# ENG-PUDSP21005-R6-PDR-MDDP.pdf Markup Summary

DESIGNED BY DLF
DRAWN BY QNA
CHECKED BY QNA
H-SCALE 1" = 100'
V-SCALE N/A
JOB NO. 1715.00
DATE ISSUED 7/24/24
SHEET NO. 6 OF 10

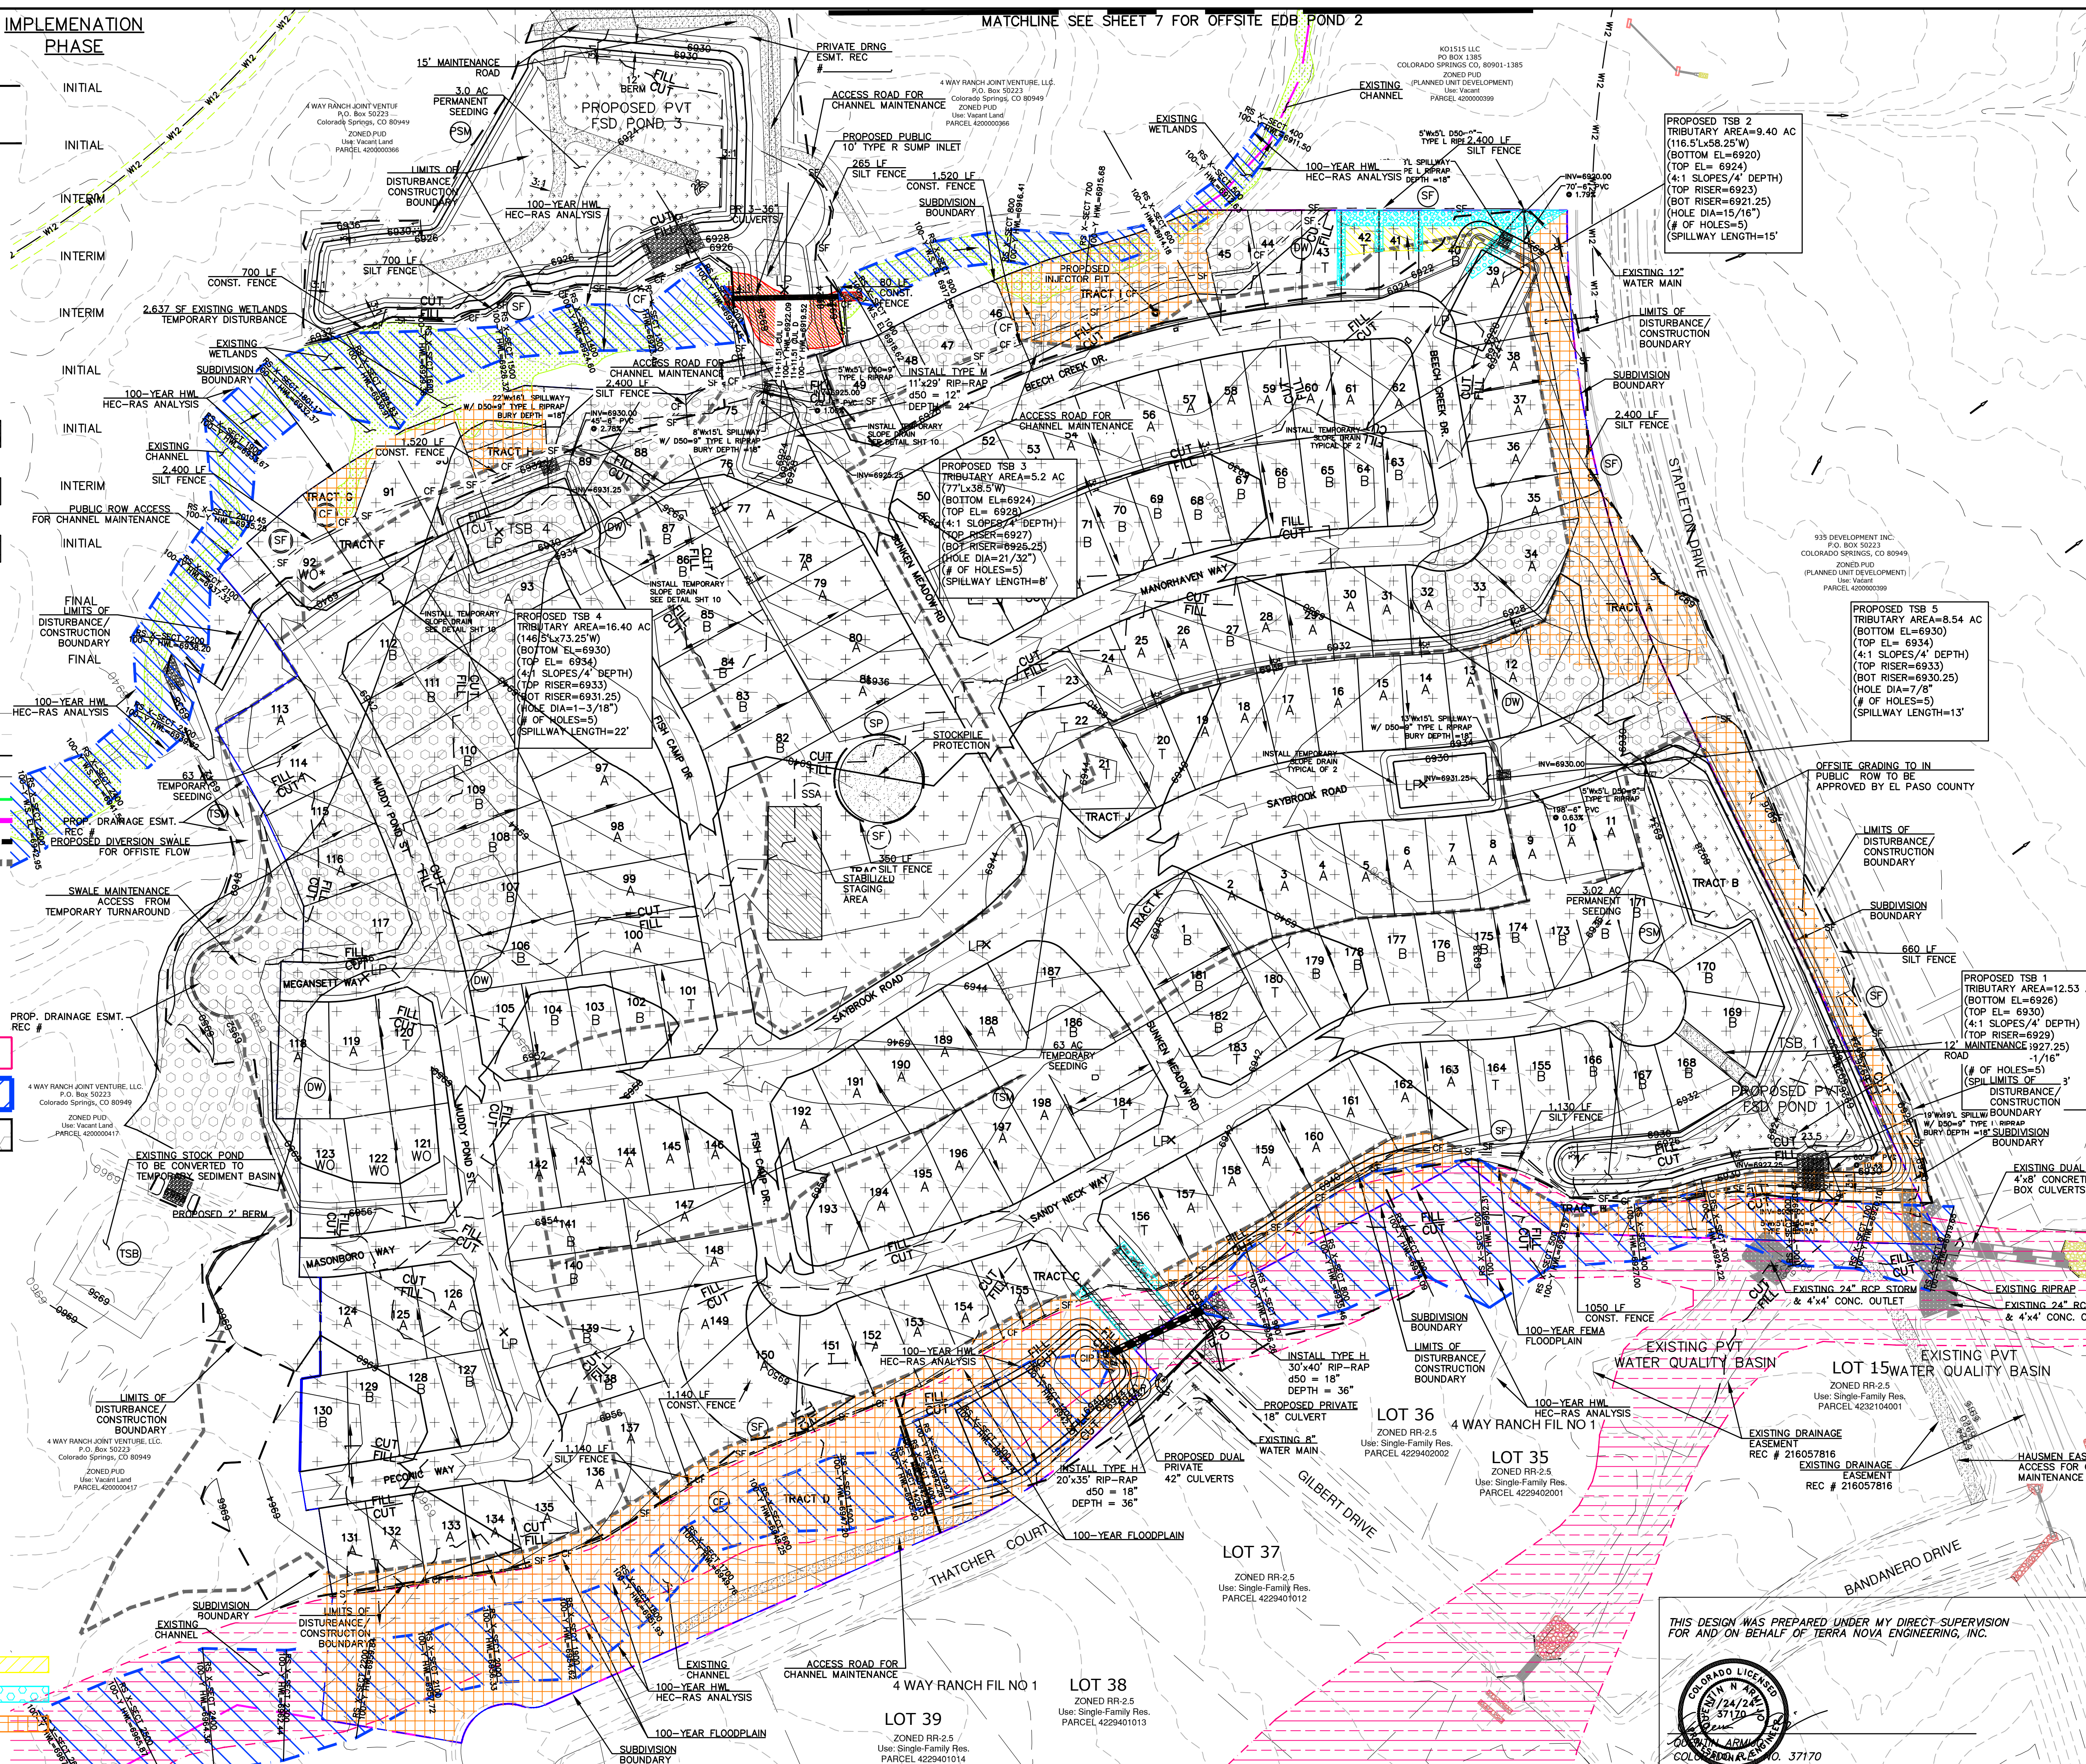
If this area is supposed to be excluded and to remain undeveloped, then that means that no building can occur on over half of each of these lots. So does that mean there is not going to be any front yards because the houses will butt-up against the sidewalk? This doesn't seem likely.

I think from a documentation standpoint we need to instead put this area into it's own WQ exclusion area (ie: a new row in the table to the right, per my comment in the last review). Utilize exclusion I.7.1.C.1.A (area excluded from WQ treatment that is <20% of the site, not to exceed 1ac).

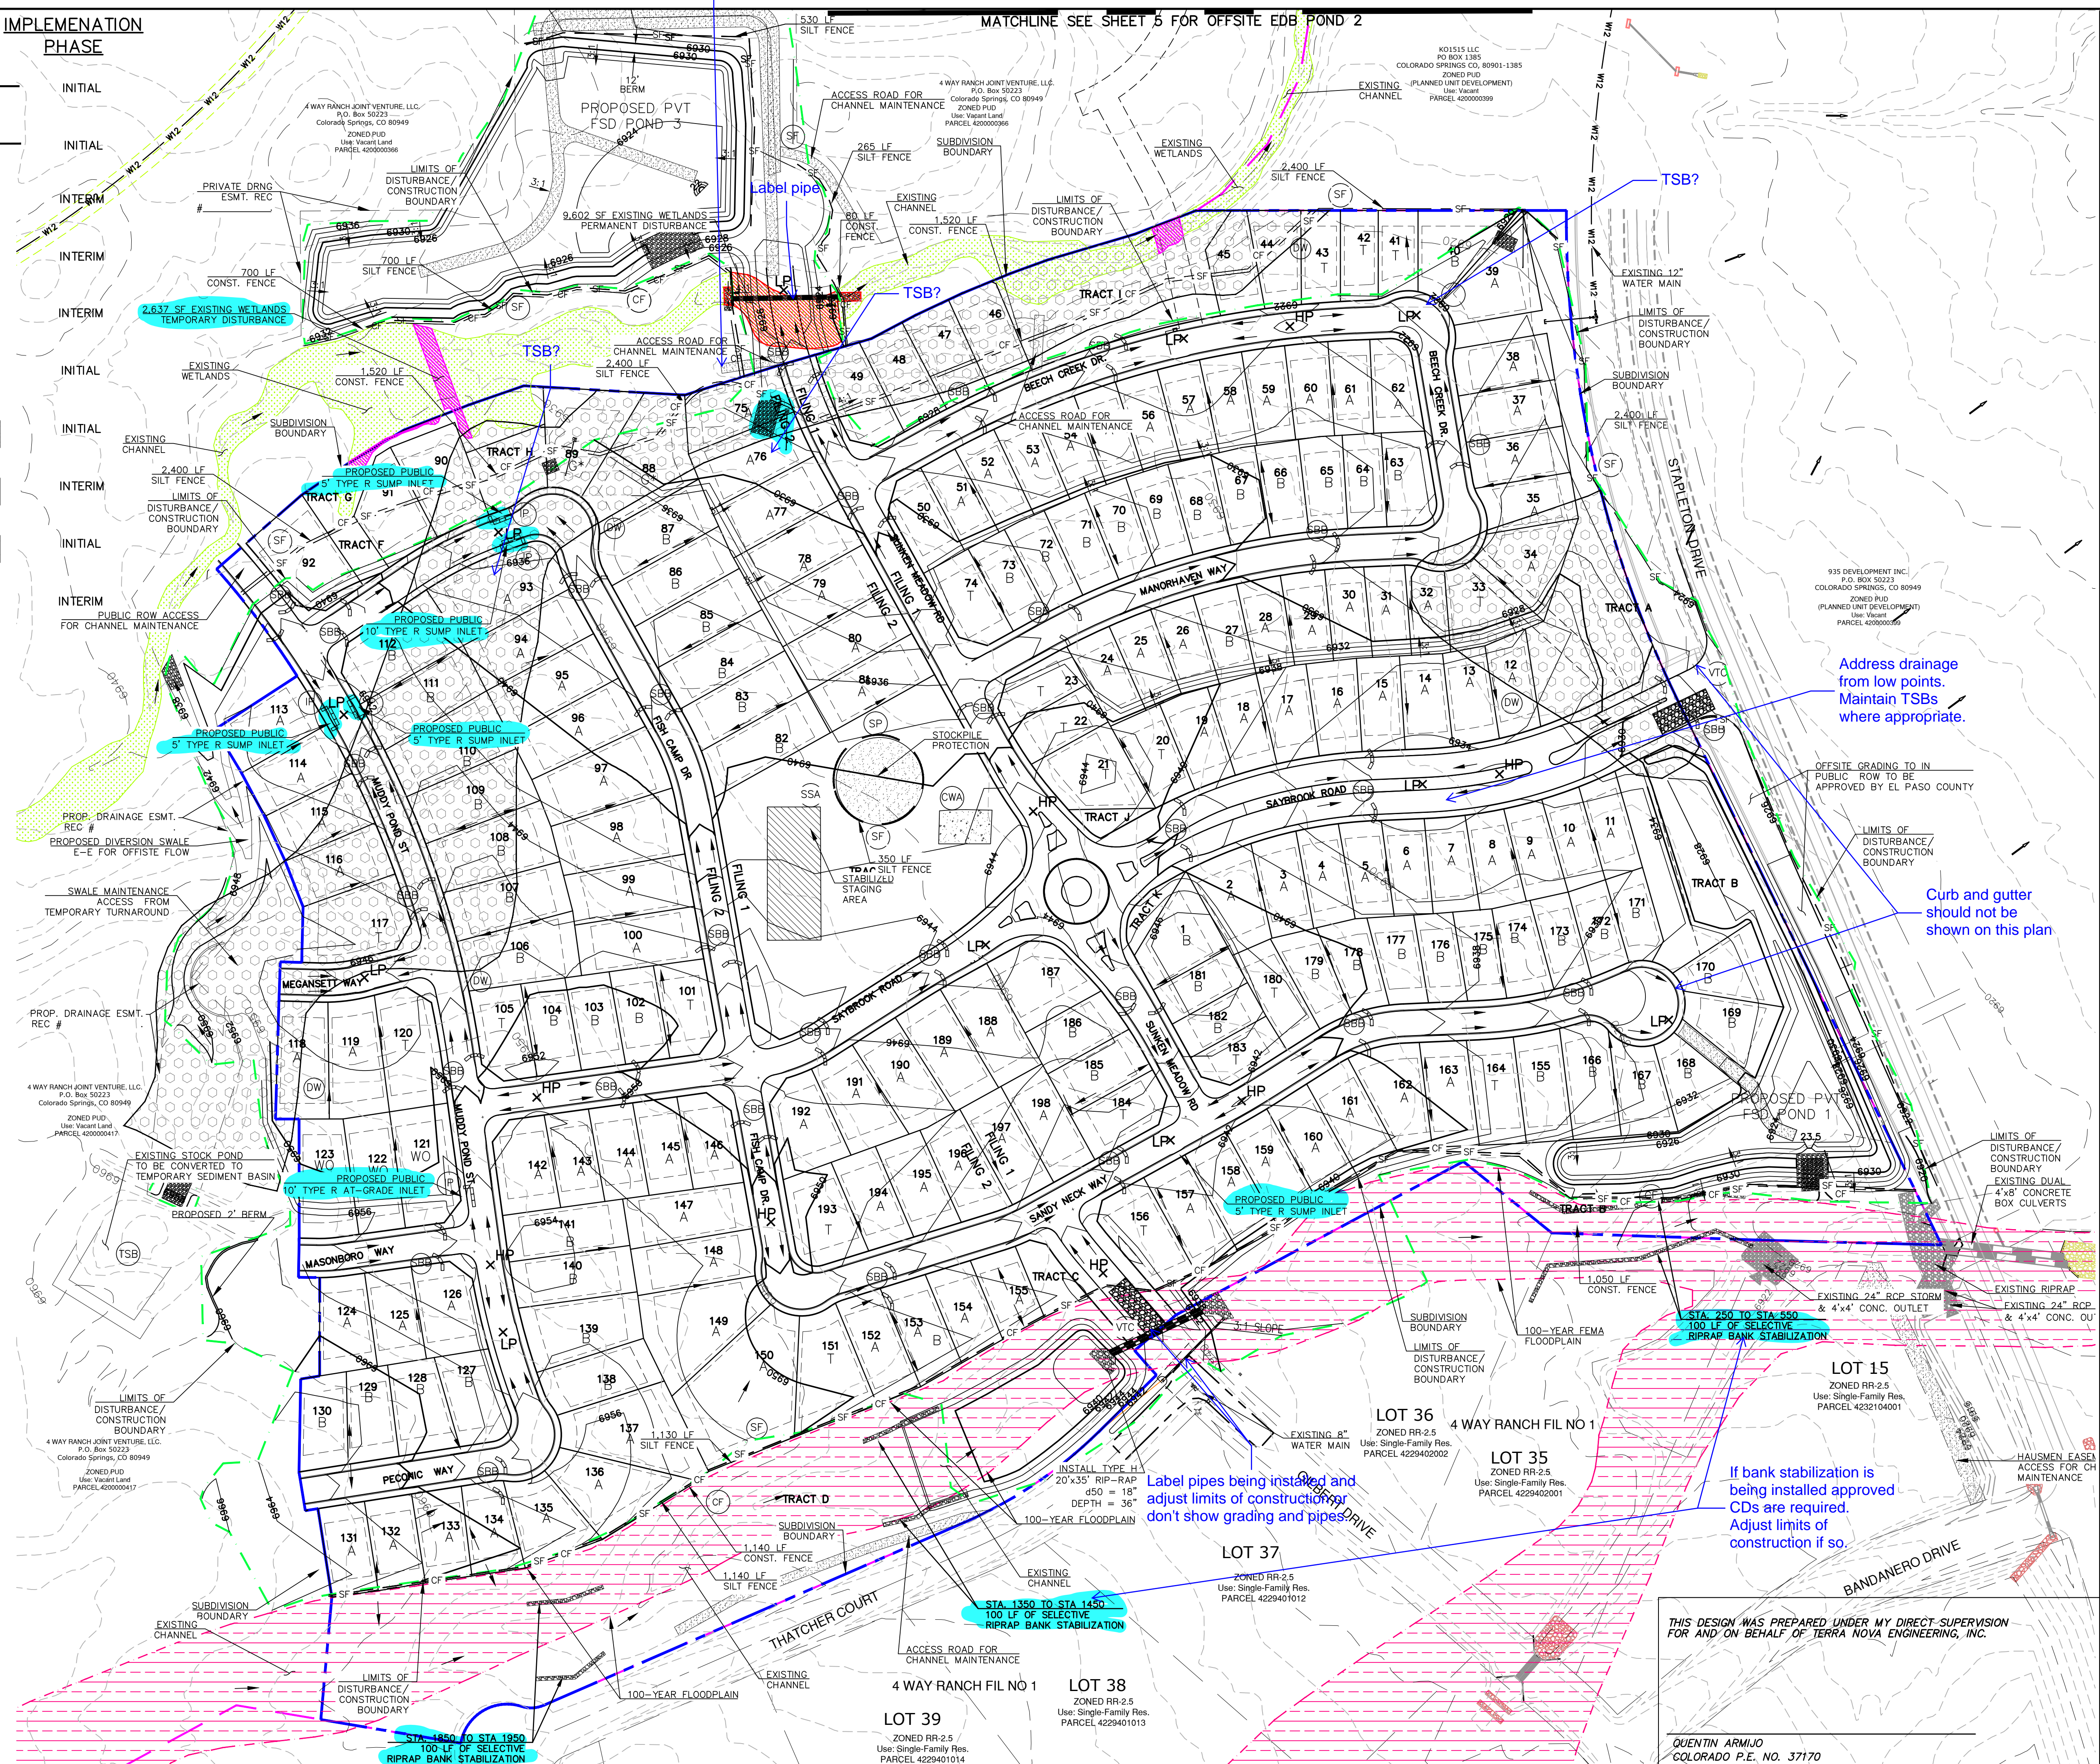
Delete duplicate contours?
